Memorandum

Date: August 30, 2019

Re: Comment Responses for PR-2019-002496

1 Site Plan - West
1" = 20'-0"

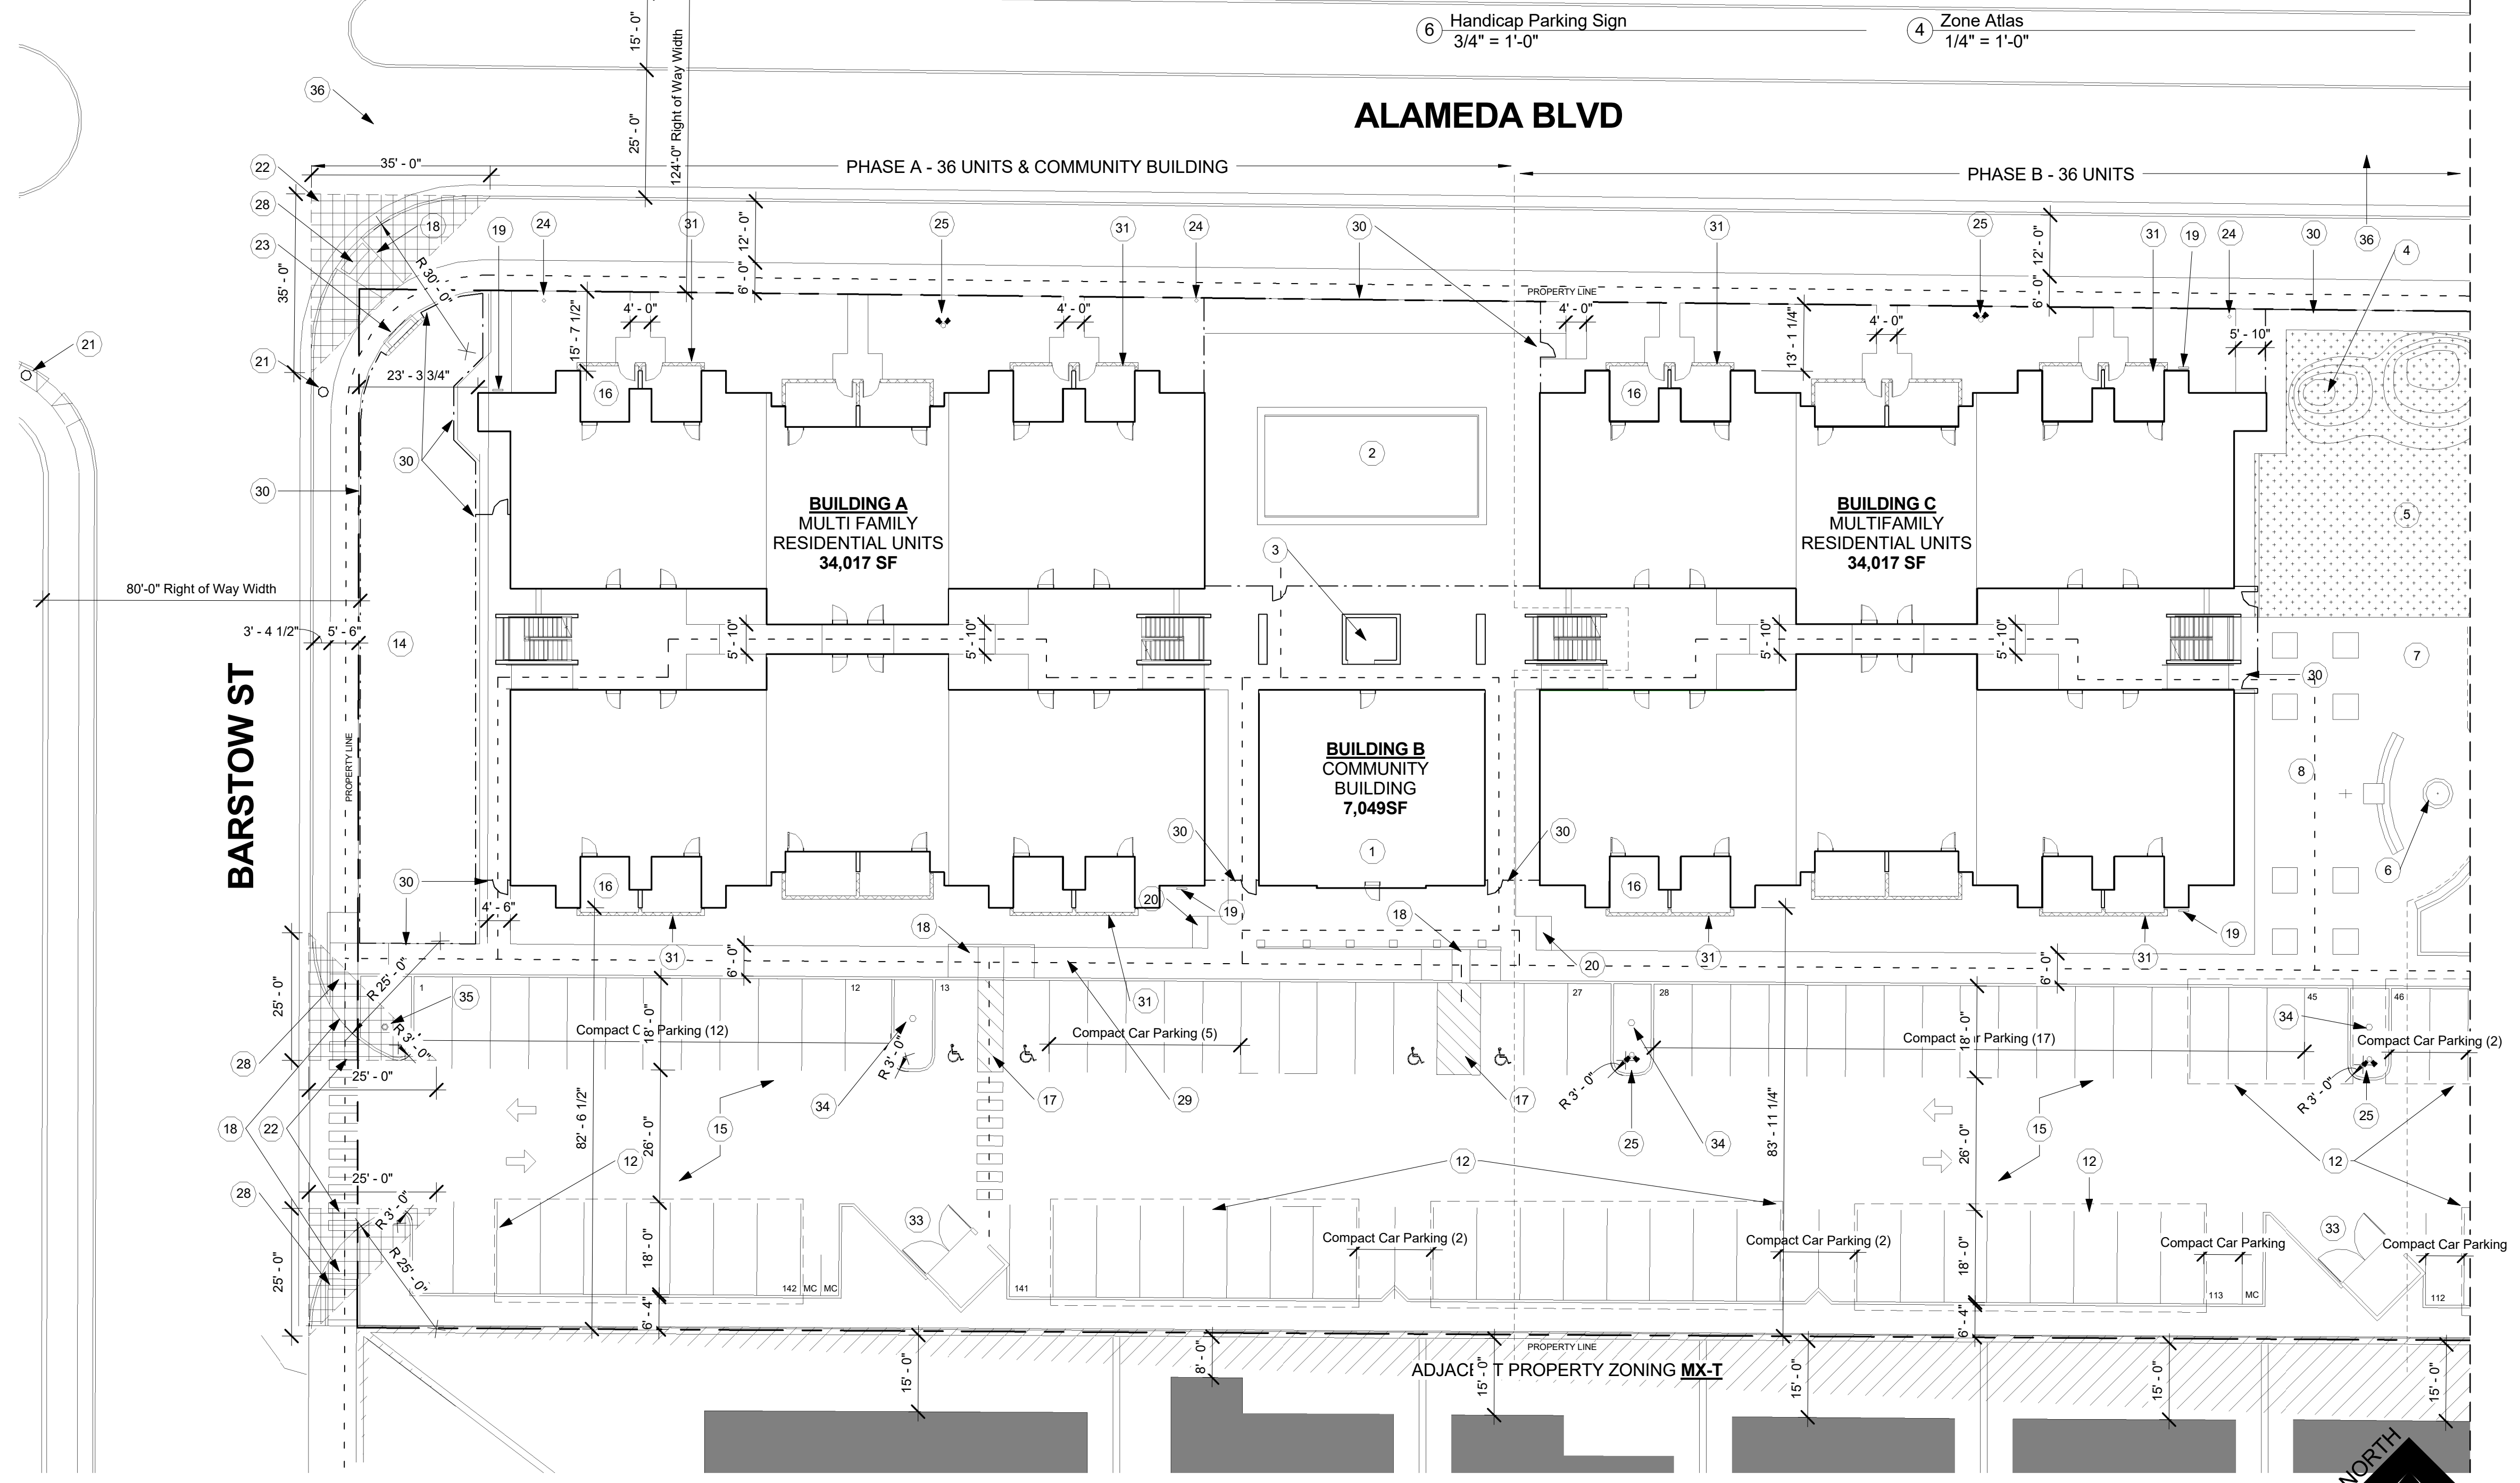
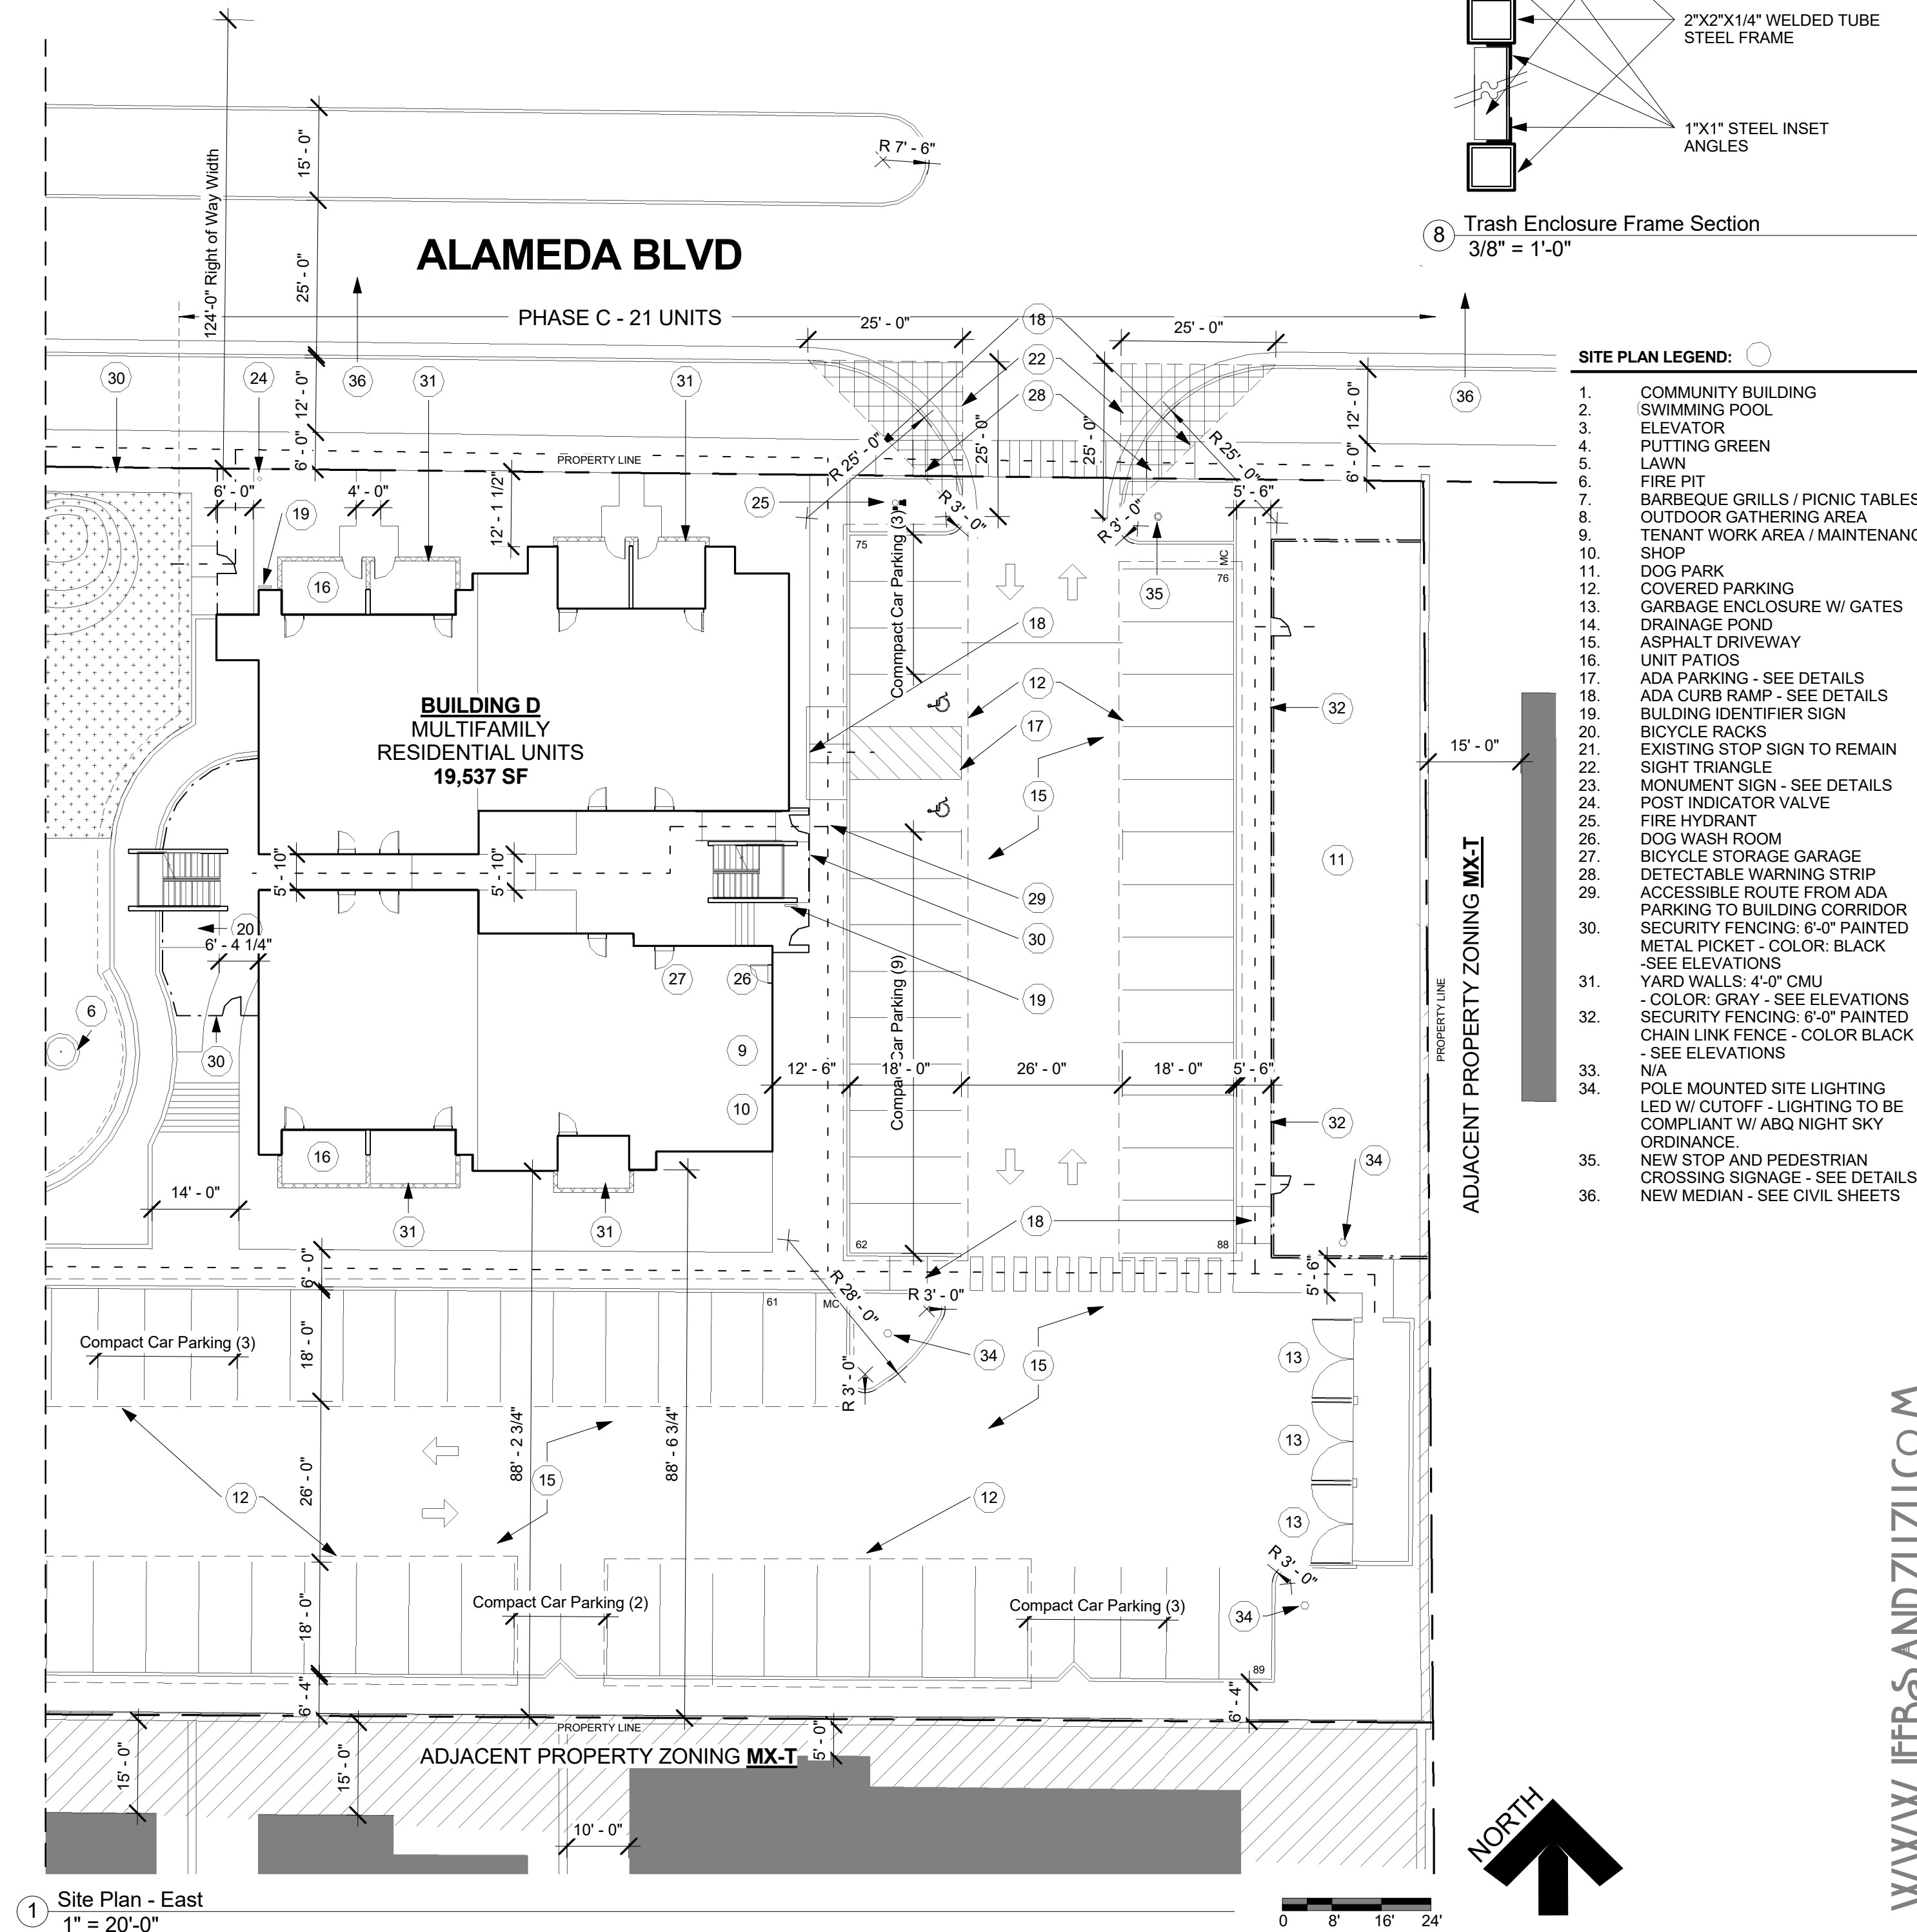
3. Clarify bicycle parking- total number of spaces 12 or 16 or 24 and secure locker spaces?
 - a. *Bicycle parking keynotes and parking calculation rectified. There are 24 spaces at racks throughout the site and 10 spaces minimum within the locker storage.*

1. According to IDO, only twenty percent of all the spaces can be compact. There are 33 compact spaces, which exceed the 20 percent as there are a total of 149 parking spaces.
 - a. *Updated site plan shows 28 compact spaces, which meets the 20% requirement. This has been added to the parking calculations on the site plan.*
2. The proposed buildings do cross existing lot lines a replat will be necessary prior to site plan sign off.
 - a. *Noted. Request condition of approval that plat be completed before final signature.*

② Phase A-West
1/8" = 1'-0"

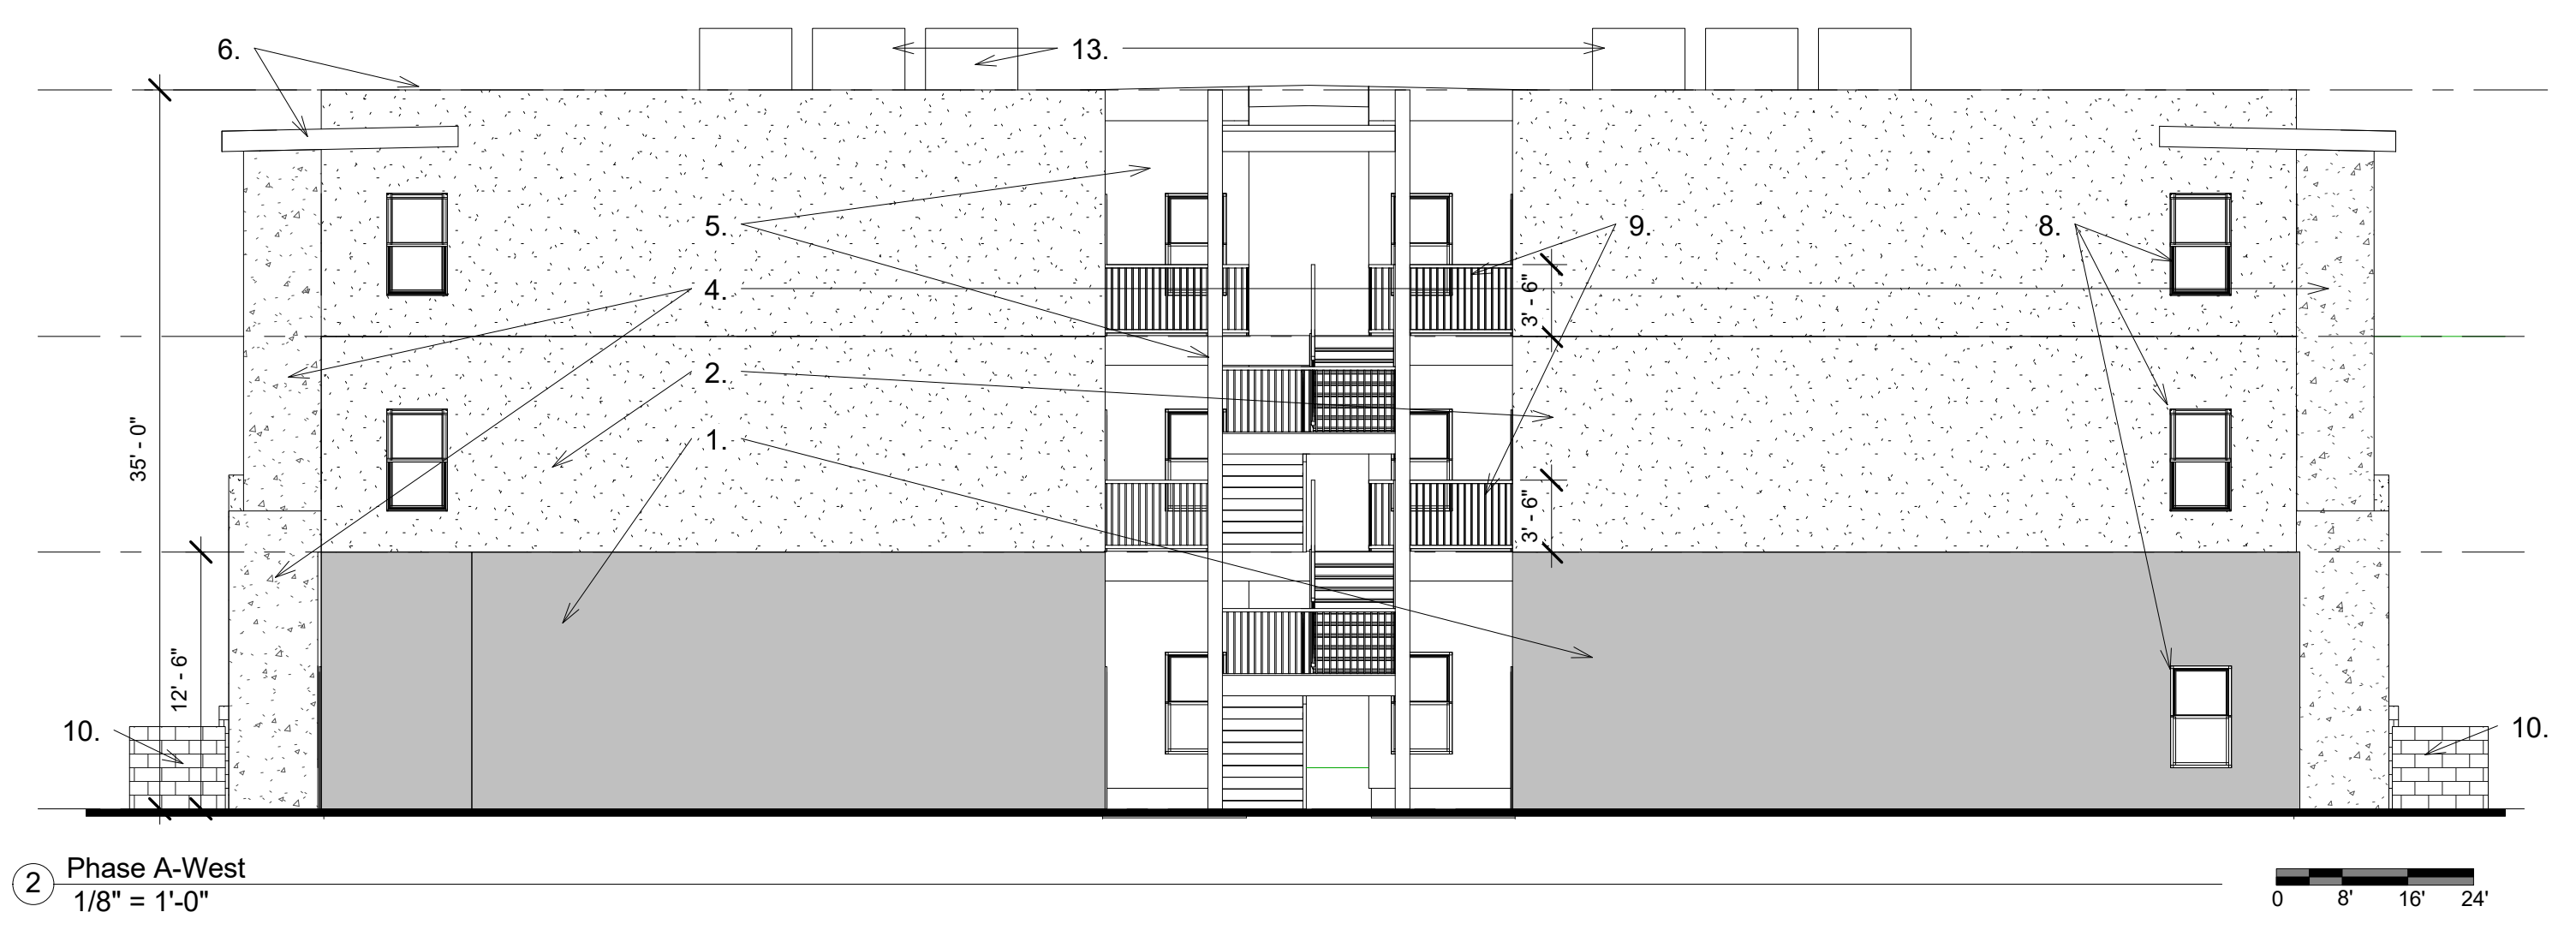
5. 5-11(E)(2)(a) - it is not clear that the building meets this requirement - please explain - west façade along Barstow does not show details shown on the color renderings that were part of the resubmittal.

- a. *Building elevation sheet has been updated to match previously shown color renderings. Ground floor is differentiated in color and with wall projections. The Barstow facade includes windows on ground floors and upper floors; pedestrian entrances via the*

common central corridor; wall plane projections and overhangs; color changes; and a proposed privately-owned mural.
